# CITY OF ALBUQUERQUE

December 10, 2018

**Re: Sunport Apartments**  
Mulberry & Bethel  
Lots A1 thru F1 & Lots 1A, Block 10, Unit 3  
**Traffic Circulation Layout**  
Engineer's/Architect's Stamp 11-29-18 (M15D036)

SUNPORT APARTMENTS
SITE PLAN
ALBUQUERQUE, NM
2930 MULBERRY S.E.
PROJECT #1844

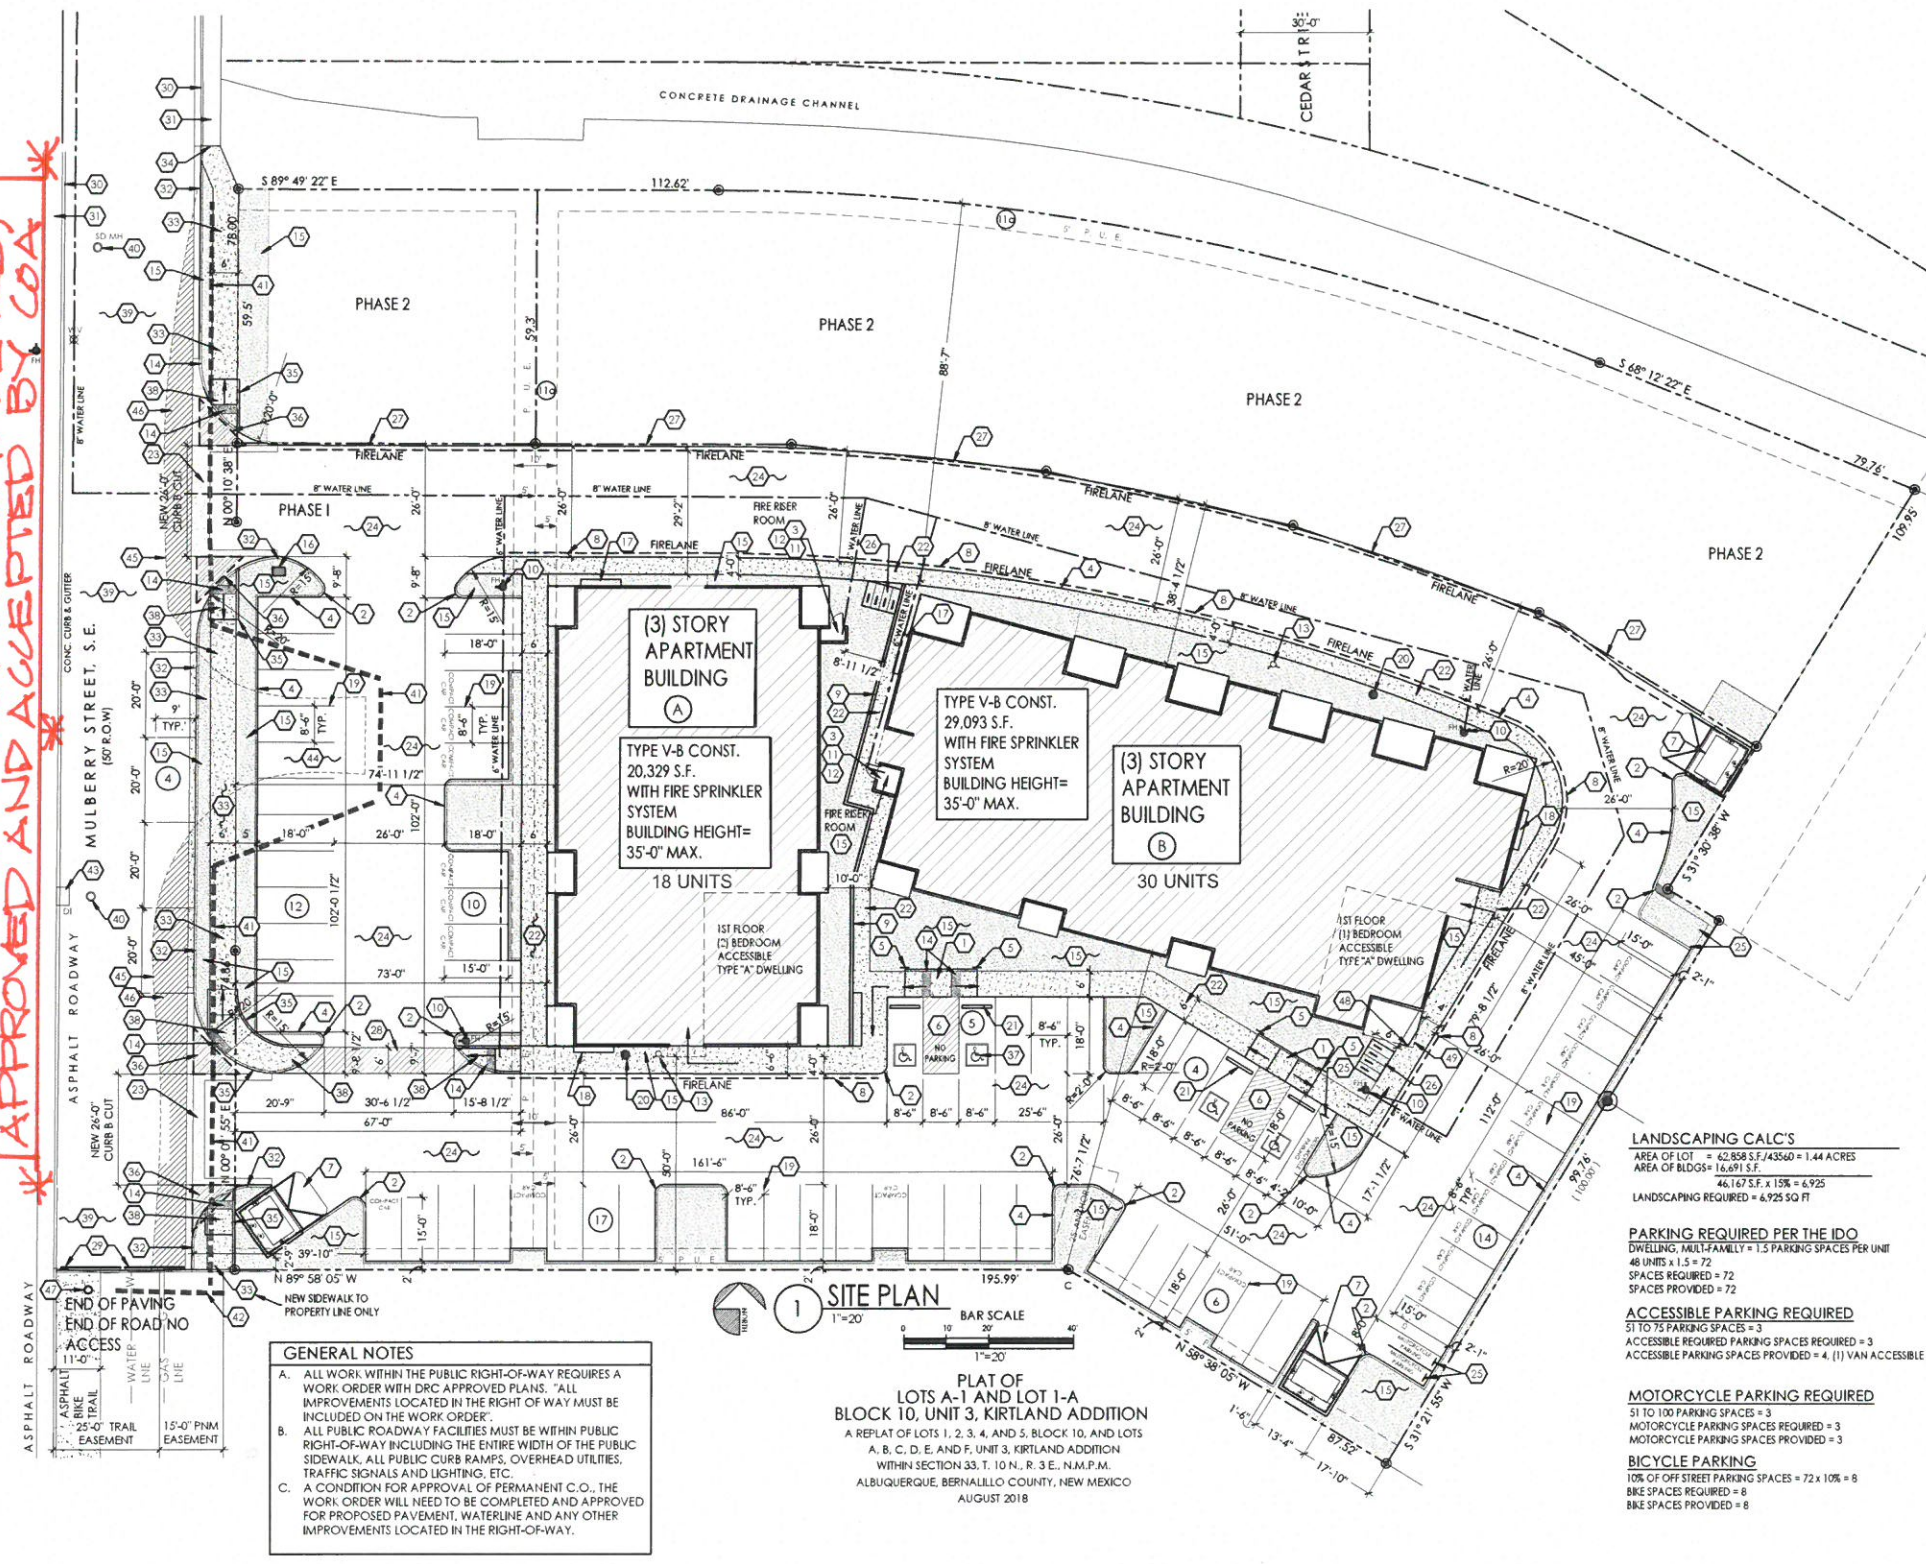
1. Please add truncated domes where necessary.
2. Corner of building on east side at building entrance cutting into walk path. Please correct 4' min.
3. Please provide copy of Final Plat.
